Case Officer: Gemma Magnuson **Recommendation:** Approve

Applicant: WH Brakspear and Sons Ltd

Proposal: Replacement kitchen extraction system including new intake grille

Drg No.  
AAN:19.706. 3

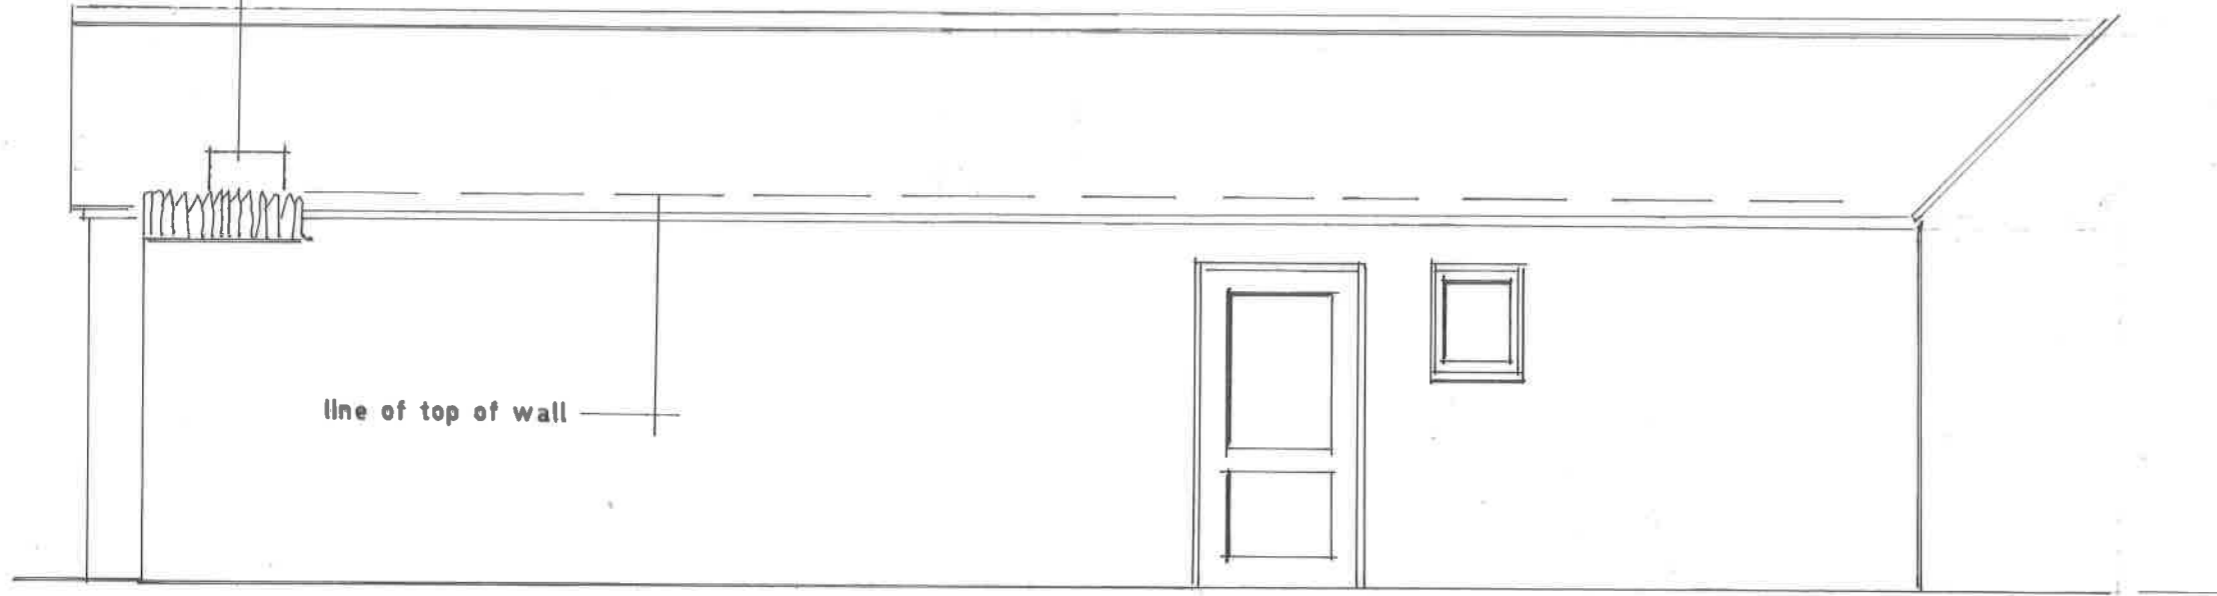
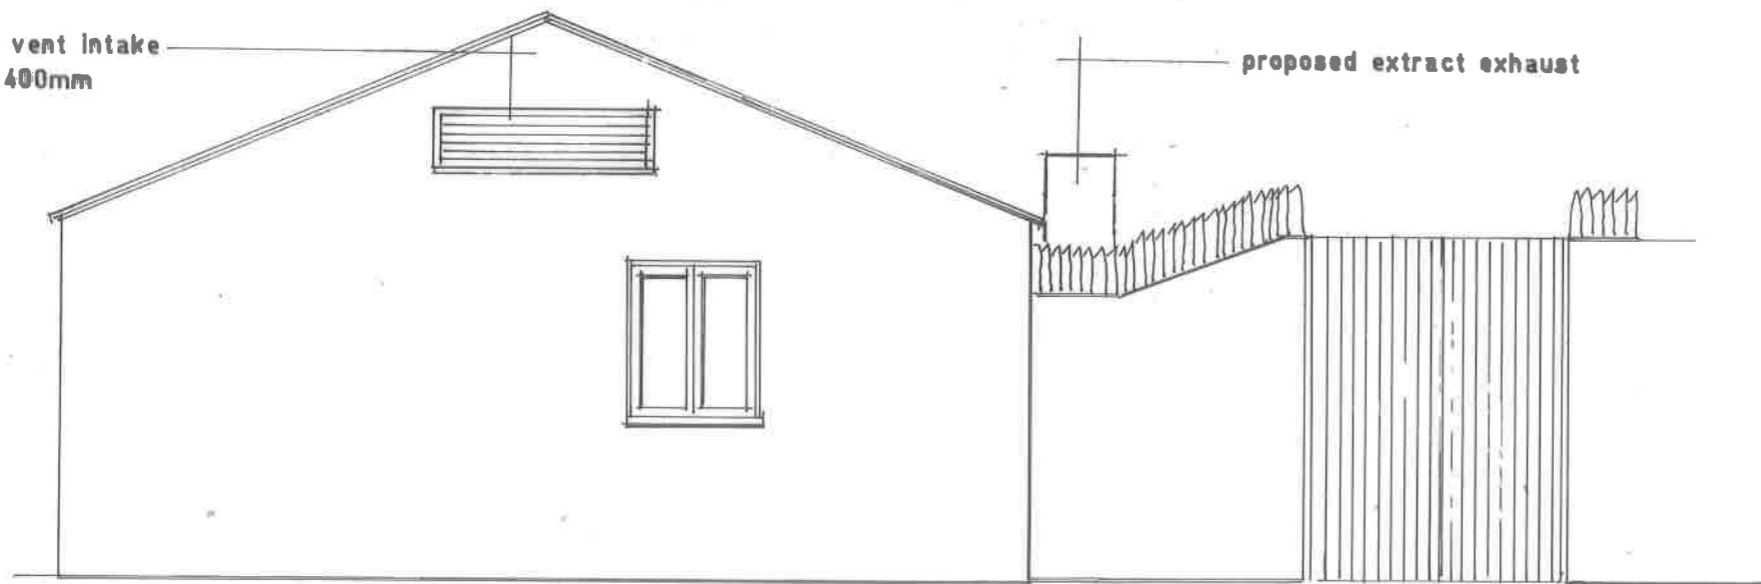
6.9. *Since that pre-app an alternative scheme has been worked up which involves an intake extract as a grill on the gable end of the building and a separate extraction unit adjacent to the building. This is considered to be a suitable compromise and although still visible reduces the impact on the listed building considerably.*

6.10. *As the kitchen has been given consent in this location (a number of years ago) there are no objections to the extraction system as proposed, which will significantly reduce the impact on the setting of the listed building.*

Unit 1 Triumph House Rigby Close Heathcote Ind Est Warwickshire CV34 6TL			TEL: 01926 887167 MOBILE: 07866 712557 e-mail ianpaish@btconnect.com	
drawing layout accepted by : date :				
Dwg. no. LIONW-OOC		NTS	Date 26/11/20	
		Drawn by	I. Paish

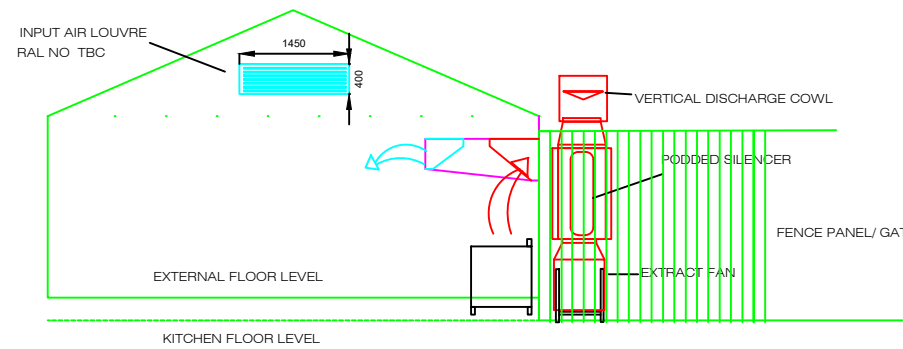
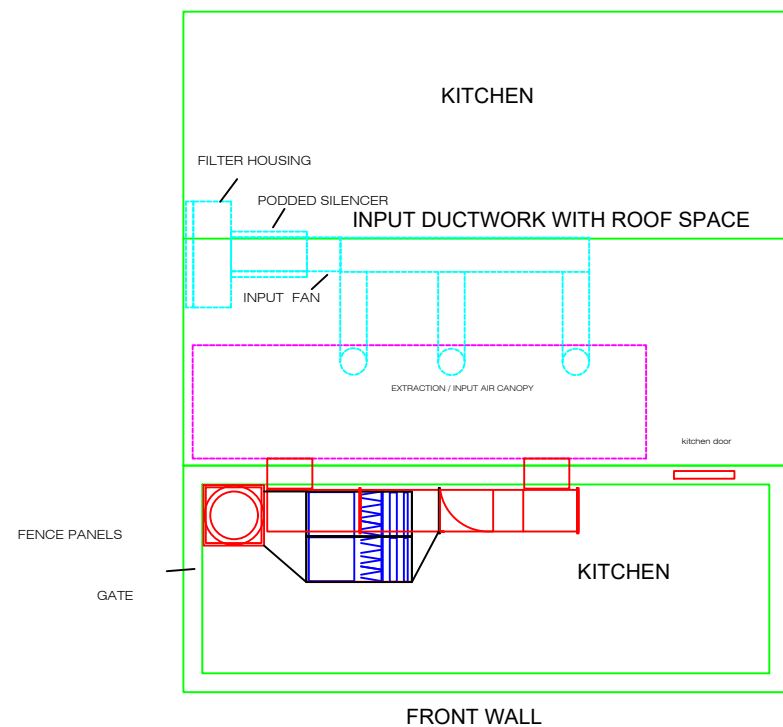
Noise: Having studied the noise report presented I am satisfied that the proposed extraction system will not cause a nuisance to the nearest residential property as long as it is built to the specification proposed. This will be an improvement to those residents living in the locality who have previously complained about the noise from the existing system.

Notwithstanding these complaints, odour is an area that we need to comment on and as the extraction system proposed is extracting at a lower level due to the listed building status and to help improve the visual impact of the scheme, the level of odour control for this scheme should be "Very High" based on the guidance provided in the EMAQ Control of Odour and Noise from Commercial Kitchen Exhaust Systems (5/9/2018).

Unfortunately, I have been unable to find any information on the odour control. Ideally this would be easy to assess and hopefully approve prior to determination, however if this is not possible then I would recommend that the following condition be placed and, on any permission, granted:

- 6.12. Given the previous history at the site I wanted to ensure that the odour control details were going to be acceptable prior to determination of the application. I therefore sought these details from the Agent and they were received on 16 December 2020.
- 6.13. The Environmental Health Officer considered that the details assuaged his concerns and made no further comment.
